**WELWYN HATFIELD BOROUGH COUNCIL
EXECUTIVE DIRECTOR - PLANNING, PUBLIC PROTECTION AND GOVERNANCE**

Application No: 6/2019/0918/HOUSE
Location: Northaw Place Coopers Lane Northaw
Proposal: Formation of a new vehicular access following removal of existing close boarded boundary fence and erection of post and rail boundary fence and hedge with timber gate
Officer: Mr William Myers

Recommendation: Refused

Drg. No
747 / SP3

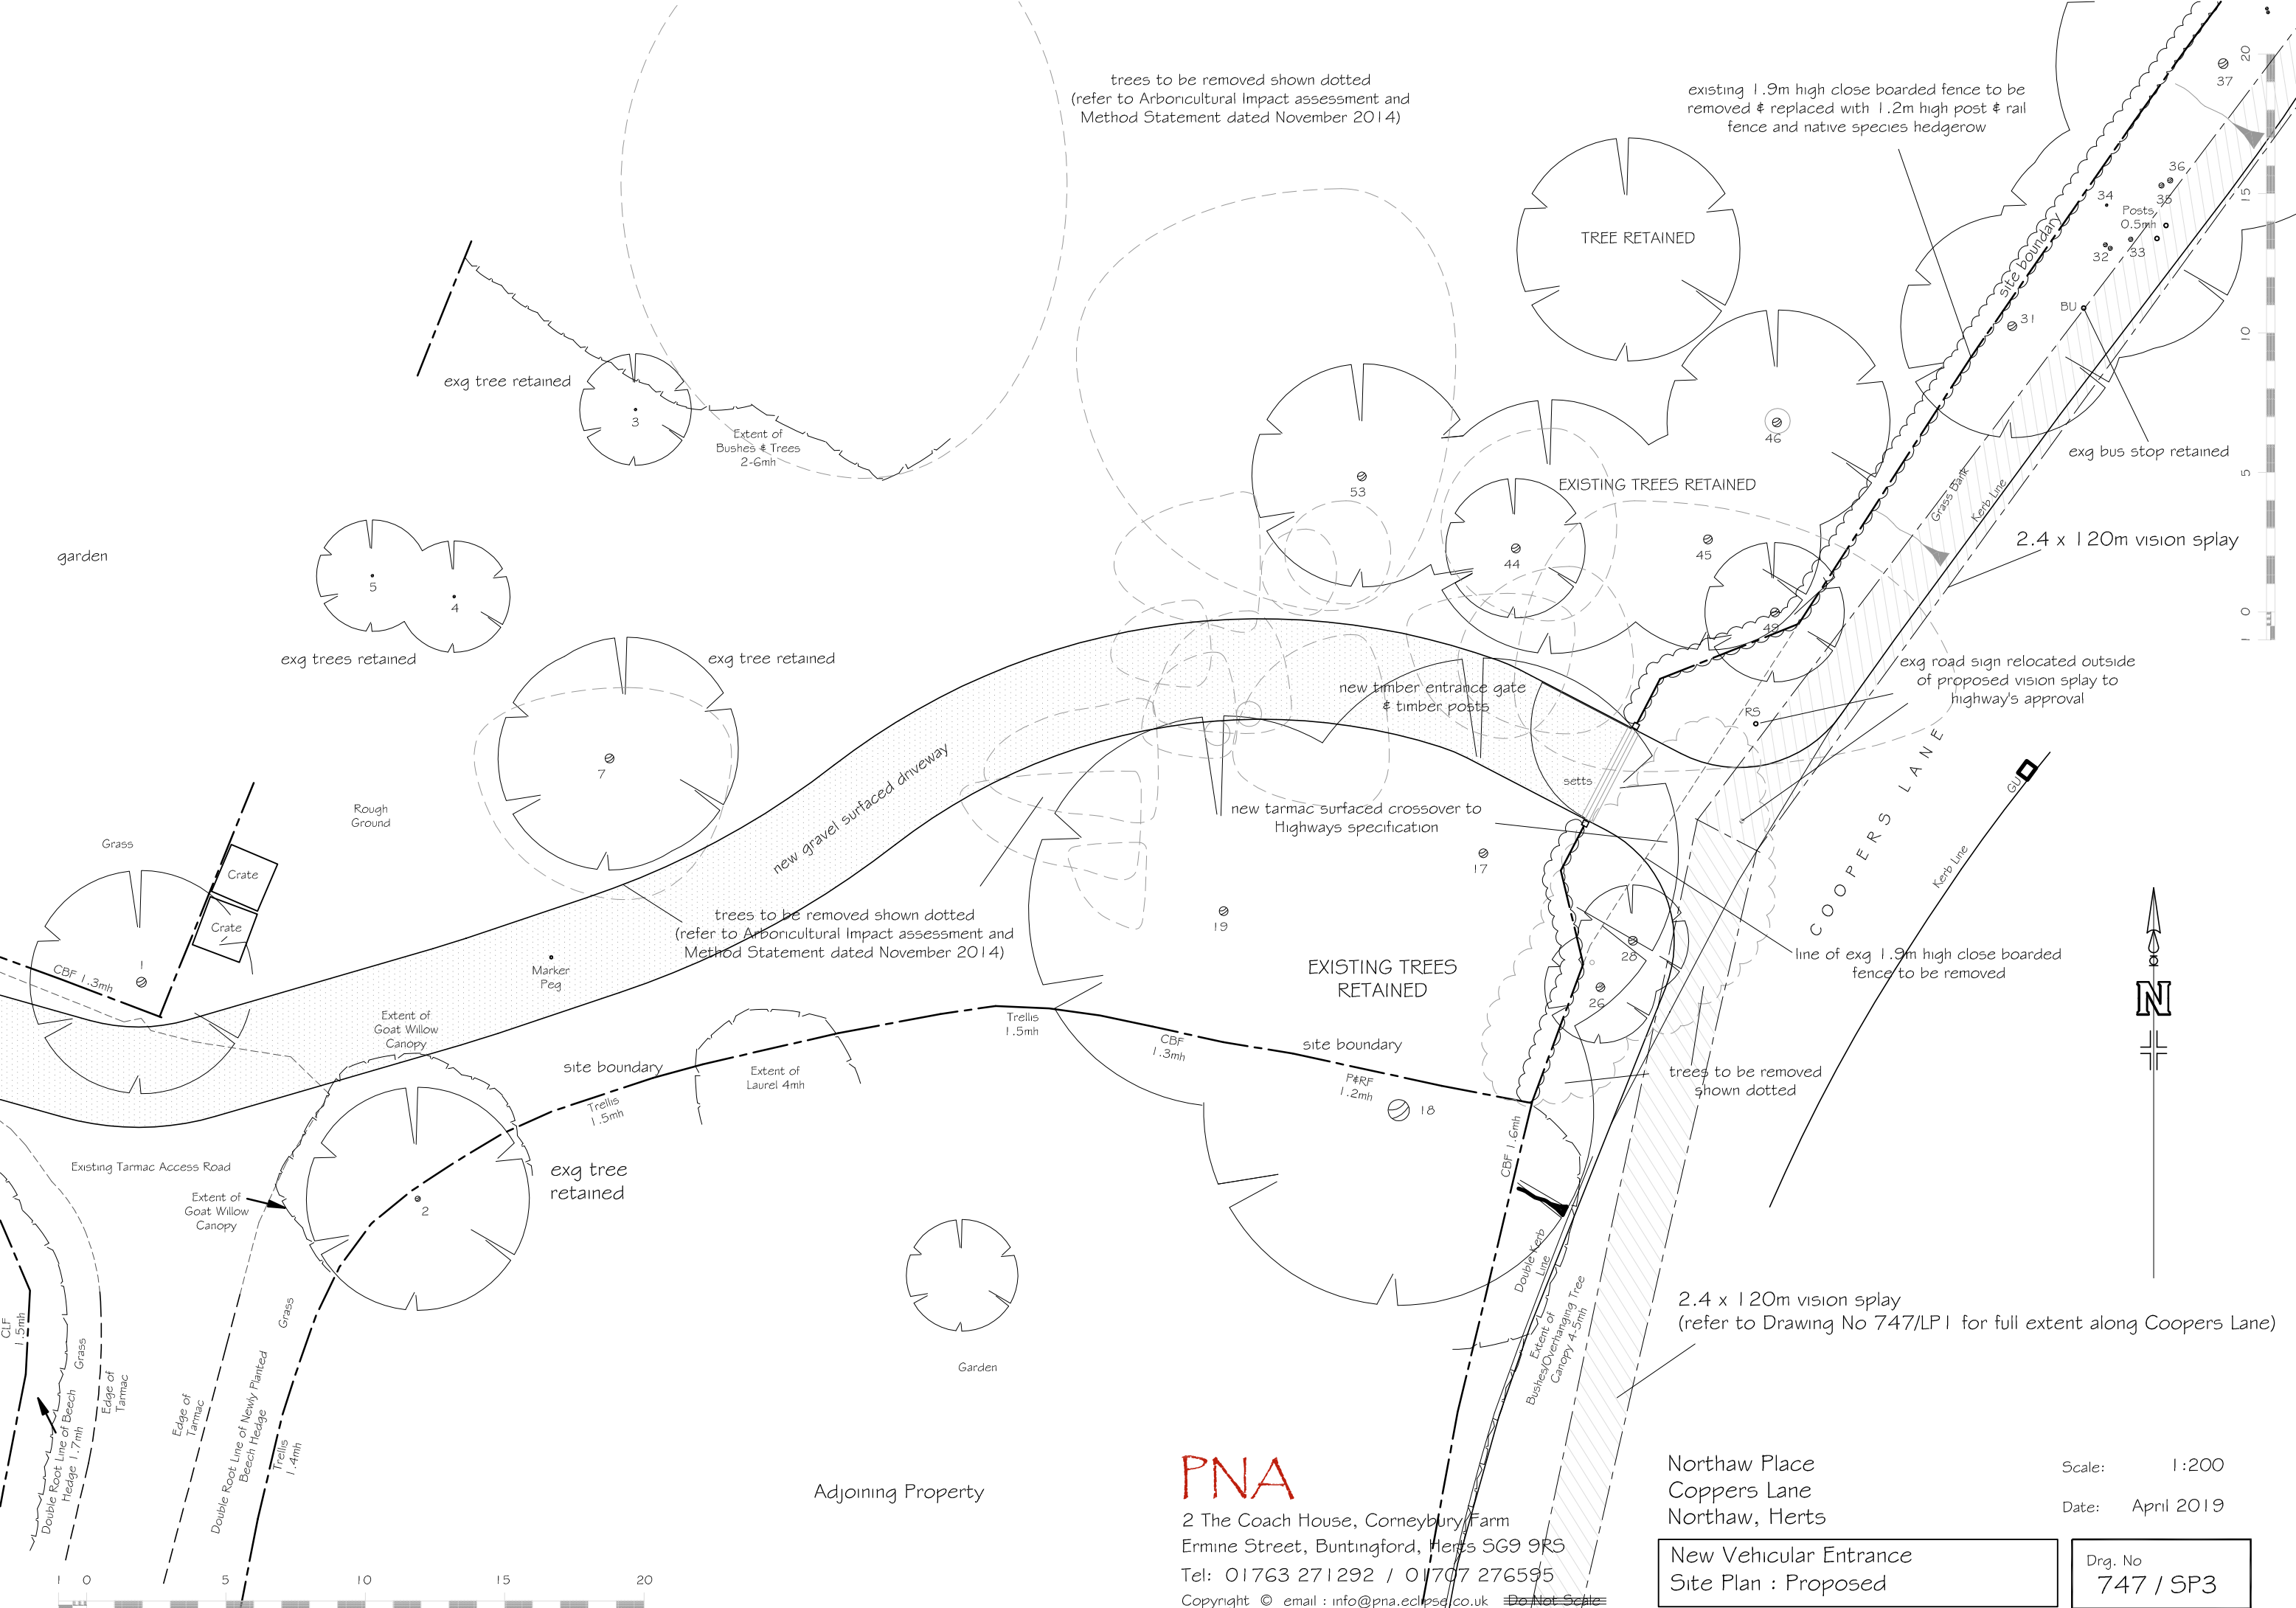
<p>boundary patterns are retained and that any new planting improves the character of the area.</p> <p>The proposed development would create a new entrance within an existing defined boundary treatment which would negatively alter the character of this section of Coopers Lane by punching a hole in this defined mature boundary treatment along this part of Coopers Lane. The gated entrance to the application site from Coopers Lane would give clear views into the site and the hardstanding that would be create to facilitate the new use of this land as a residential driveway. Although no objection is raised to the proposed replacement fence, it is considered this would only have neutral impact.</p> <p>Further to the above, it is therefore considered that the proposed use and associated hardstanding would not be in keeping with its surroundings and would be visually intrusive and out of keeping with character of the area. The proposal is therefore, contrary to Policies D1, D2 and RA10 of the Welwyn Hatfield District Plan 2005.</p>

Insufficient information has been provided as part of this application to enable the Local Planning Authority to fully assess the highway risks arising from the proposed development and to demonstrate that the development would not result in an unacceptable impact on highway safety. Accordingly the proposed development poses a risk to highway safety, contrary to proposed development would not accord with Policy SADM2 of the Emerging Local Plan 2016 and the National Planning Policy Framework.

1. By virtue of its scale and appearance, the development spreads built form into what was previously undeveloped land and, as such, fails to assist in safeguarding the countryside from encroachment, contrary to paragraph 134 of the National Planning Policy Framework 2019. The formation of a driveway would also harm the openness and the appearance of the Green Belt in this location. The proposal is therefore inappropriate development in the Green Belt. Very special circumstances to outweigh the harm to the Green Belt do not exist as the harm to the Green Belt and other harms, are not clearly outweighed by other considerations. Accordingly, the development is contrary to Policies GBSP1 and GBSP2 of the Welwyn Hatfield District Plan 2005; Policy SP3 and SADM34 of the Council's Draft Local Plan Proposed Submission 2016; and the National Planning Policy Framework 2019.

2. The development of this site is considered to result in an unacceptable erosion of the demonstrable physical attributes within the Landscape Character Area and would neither conserve, maintain, enhance nor strengthen the character of the wider surrounding area. As such, the proposal is not considered to comply with Policies D1, D2 and RA10 of the Welwyn Hatfield District Plan 2005; Policies SP9 and SADM16 of the Council's Draft Local Plan Proposed Submission 2016; and the National Planning Policy Framework 2019.

3. Insufficient information has been provided as part of this application to enable the Local Planning Authority to fully assess the highway risks arising from the proposed development and to demonstrate that the development would not result in an unacceptable impact on highway safety. Accordingly the proposed development poses a risk to highway safety, contrary to proposed development would not accord with Policy SADM2 of the Emerging Local Plan 2016 and the National Planning Policy Framework 2019.
